Rezoning Petition Review

Date of Review: March 6, 2008

Rezoning Petition #: 08-70

Location of Property: Approximately 3.63 acres located in the block bounded by N Davidson Street, E 26th Street, E 27th Street and Yadkin Avenue

DATE: January 3, 2008  
 DESIGNED BY: CCM  
 DRAWN BY: SK  
 CHECKED BY: CCM  
 SCALE: 1" = 40'  
 PROJECT #: 1007324  
 SHEET #:  
**RZ-1.0**

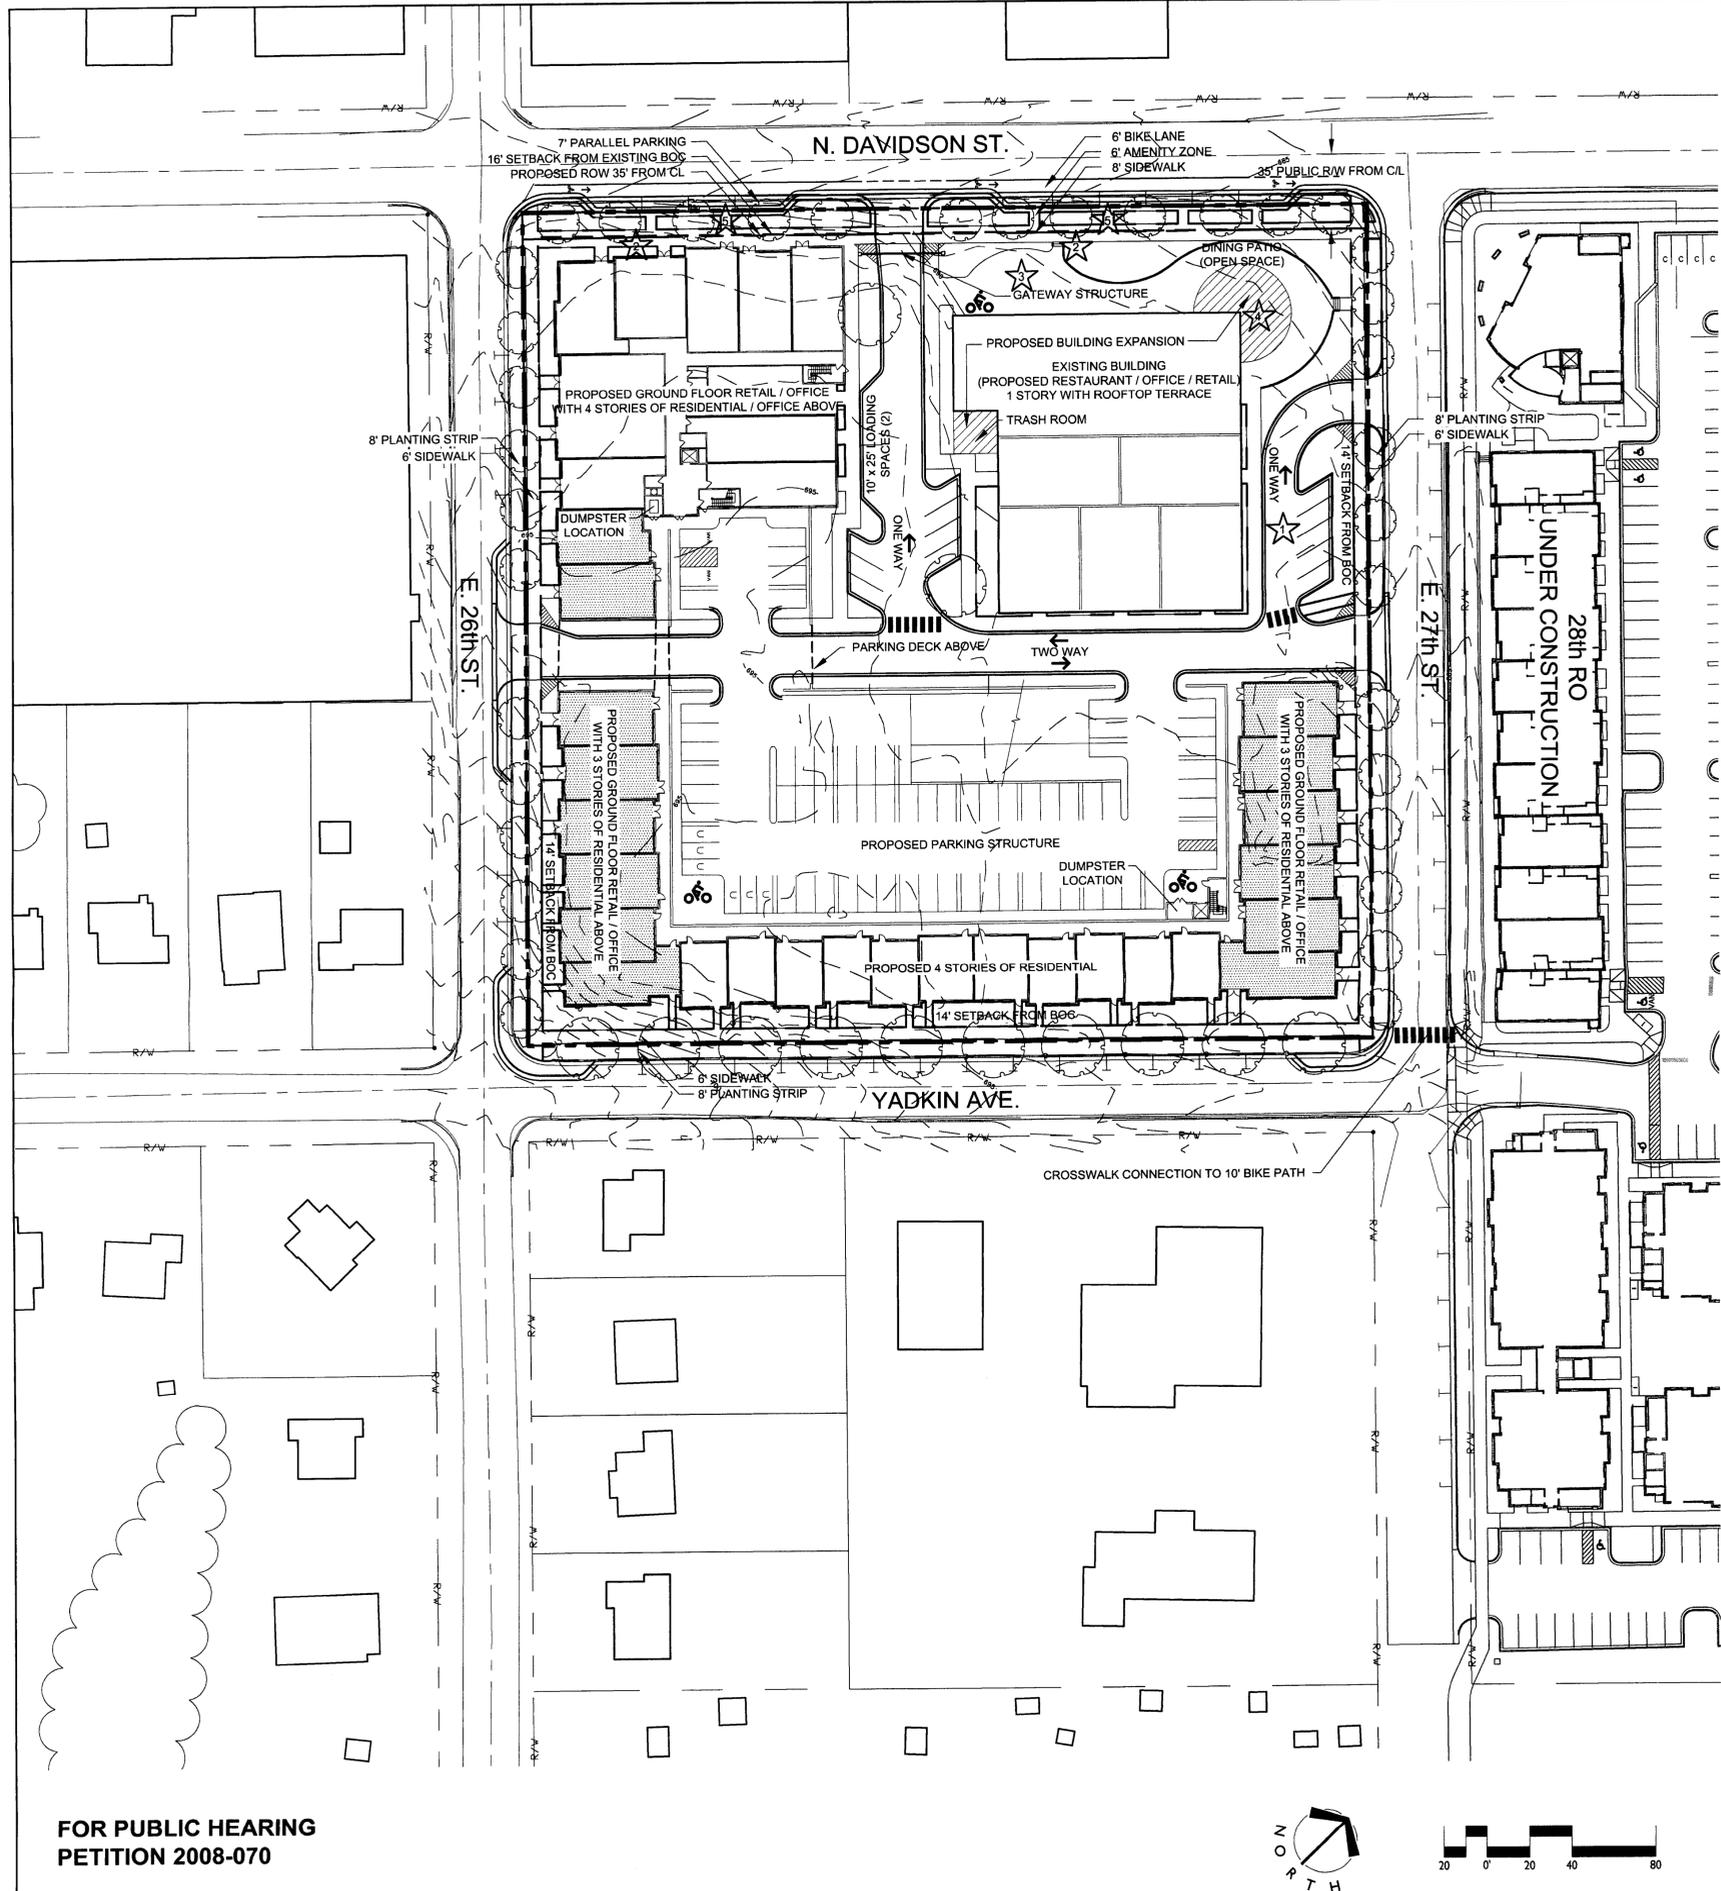
Recommendations Concerning Storm Water: **Remove Storm Water Quality and Peak Control Notes and Include the following notes on the petition.**

The petitioner shall comply with the Charlotte City Council approved and adopted Post Construction Controls Ordinance.
